**Consultation Response from KC,  
Trees**

**2025/90768 Land Adj, 2, Hopton Hall Lane, Upper Hopton, Mirfield, WF14 8EP**

**Erection of detached dwelling and associated external works**

**Date Responded: 21/05/2025**

ADDRESS: Park Farm, Hopton Hall Lane,
Mirfield, West Yorkshire, WF14 8EP.
JCA REF: 22345-A/AJB

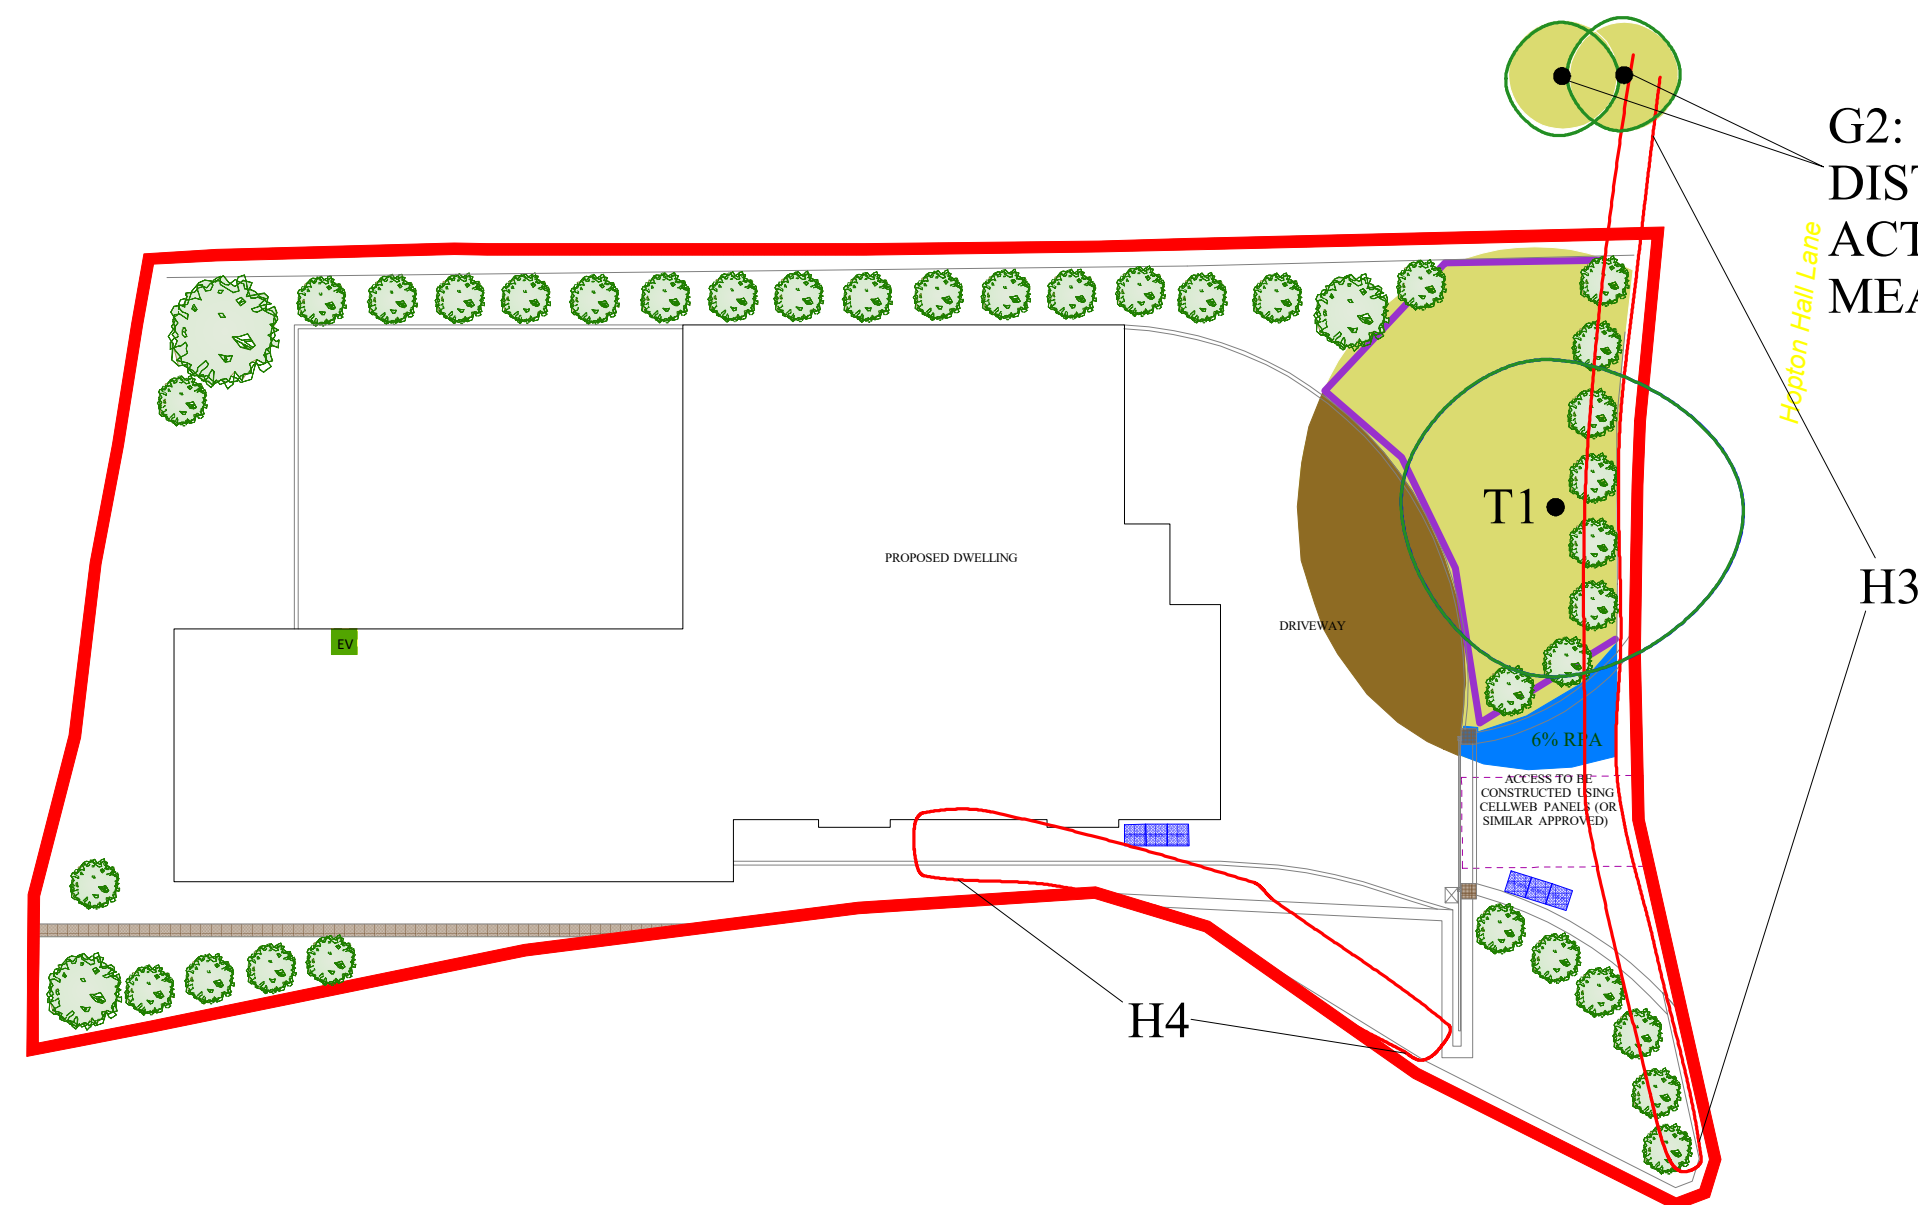
Once again, as stated previously, these proposals cause concern from an arboricultural perspective, as the total overlap of the driveway and access route covers a significant portion of the total RPA. According to BS5837: 2012 new permanent hard surfacing should not exceed 20% of any existing unsurfaced ground within the RPA.

It is acknowledged that a pink rectangular area has been added to access driveway to suggest that it could be constructed using cellweb panels however, the AMS details root pruning within the blue portion of the RPA. Therefore, the use of Cellweb in this area would be somewhat redundant as tree roots would already be severed in this area to accommodate the proposals.

There remains an objection to the development from an arboricultural perspective.
